**OXFORDSHIRE COUNTY COUNCIL’S RESPONSE TO CONSULTATION
ON THE FOLLOWING DEVELOPMENT PROPOSAL**

Application no: 24/00539/F

Proposal: Erection of a stadium (Use Class F2) with flexible commercial and community facilities and uses including for conferences, exhibitions, education, and other events, club shop, public restaurant, bar, health and wellbeing facility/clinic, and gym (Use Class E/Sui Generis), hotel (Use Class C1), external concourse/fan-zone, car and cycle parking, access and highway works, utilities, public realm, landscaping and all associated and ancillary works and structures

Transport Development Management – Interim Response

APPENDIX A – MASTERPLAN

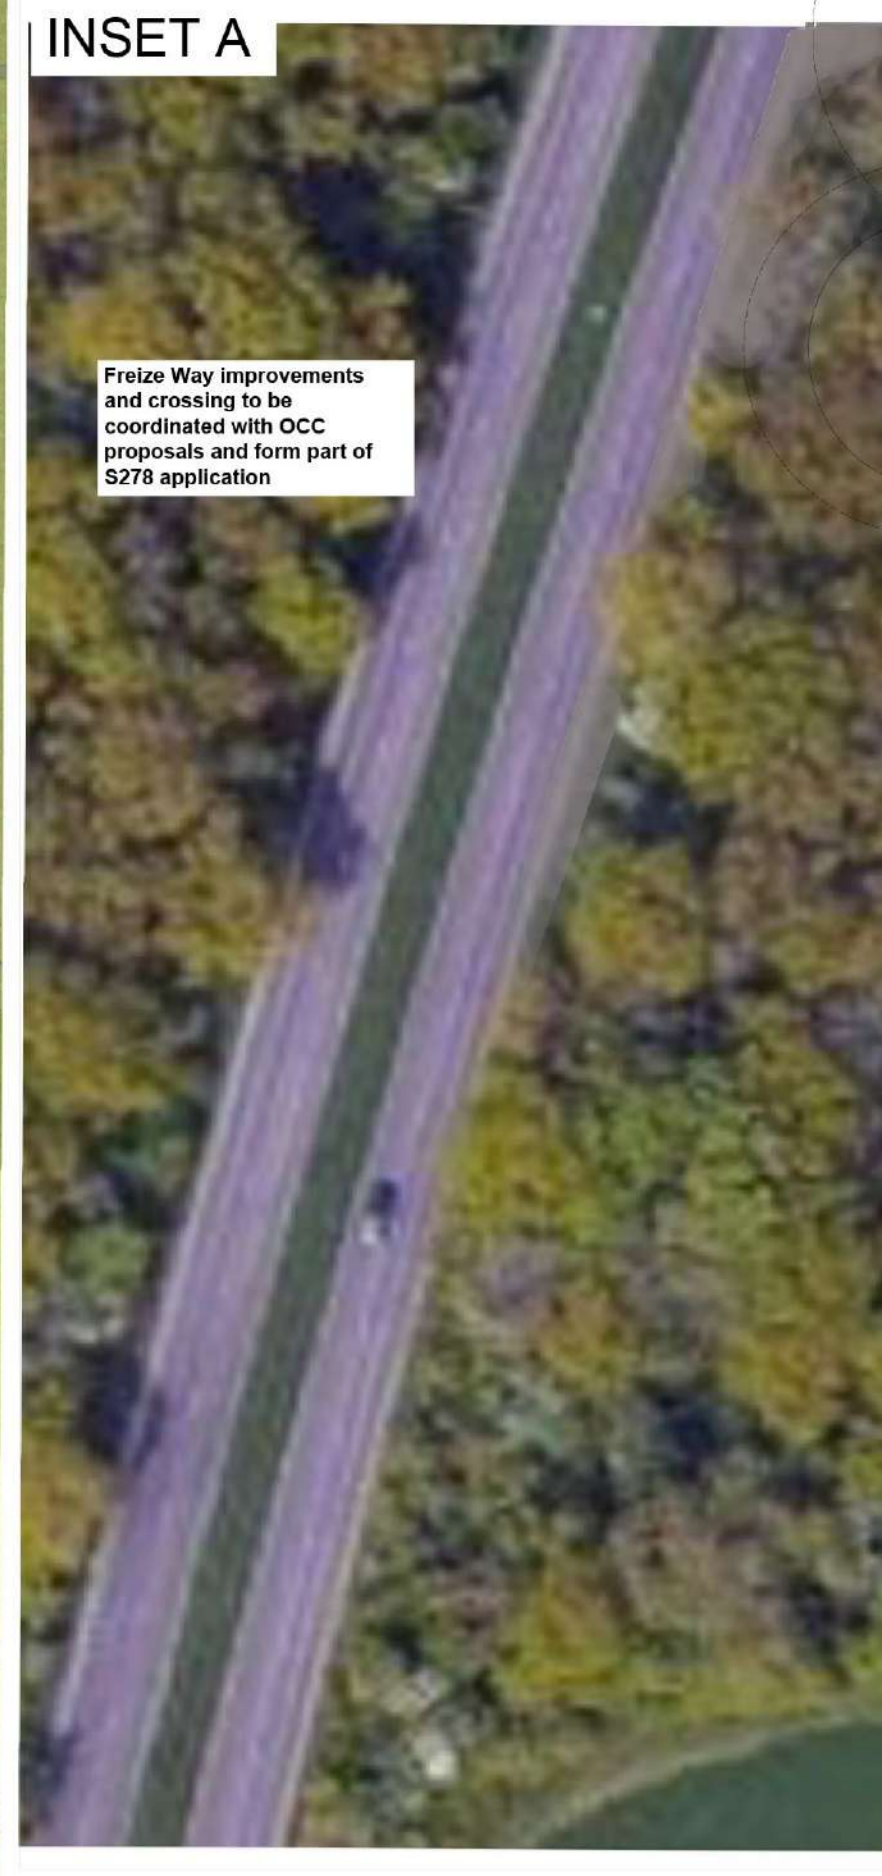
- The applicant must demonstrate how the proposed ‘Cycle Superhighway’ along Oxford Road will continue across their site frontage. The cycle superhighway must be continuous, which the current plans do not appear to show. The width of the cycle lane must be 2.5m with a 2m footway and floating bus stops. Again, due to the frequency of the bus services there must be a minimum of 2 bays with shelters and RTI displays.

- All cycle parking must be provided in accordance with County Council standards. It will not be acceptable to monitor the need for cycle parking through the travel plan and provide spaces later, so an objection will be raised unless a solution is identified. A minimum of 645 spaces are required, only 150 spaces are proposed at the stadium in the current application plans which is well below that number and no plans have been provided showing the form of these spaces which will need to be covered, secure and accessible. The existing cycle parking spaces at Oxford Parkway cannot be counted towards the requirement for the stadium as these are for the station. A new Cycle Hub at Parkway (similar to that at Didcot Parkway) should be provided but is unlikely to be big enough for the almost 500 spaces the club still need to find. There is space available for this next to the P&R building on Parkway, but a plan must be submitted showing this.

- Further drawings of the access works are required showing detailed geometry and dimensions. The signalised crossing will need to be staggered unless the island is at least 5m wide. There should be no pedestrian fences and there should be room for bicycles with trailers to use the crossing easily. The crossing cannot be located within the slip road into the site so this needs to be redesigned and adequate drawings provided. At 30mph and with the level of traffic expected to use the access the slip road into the site is likely not required.
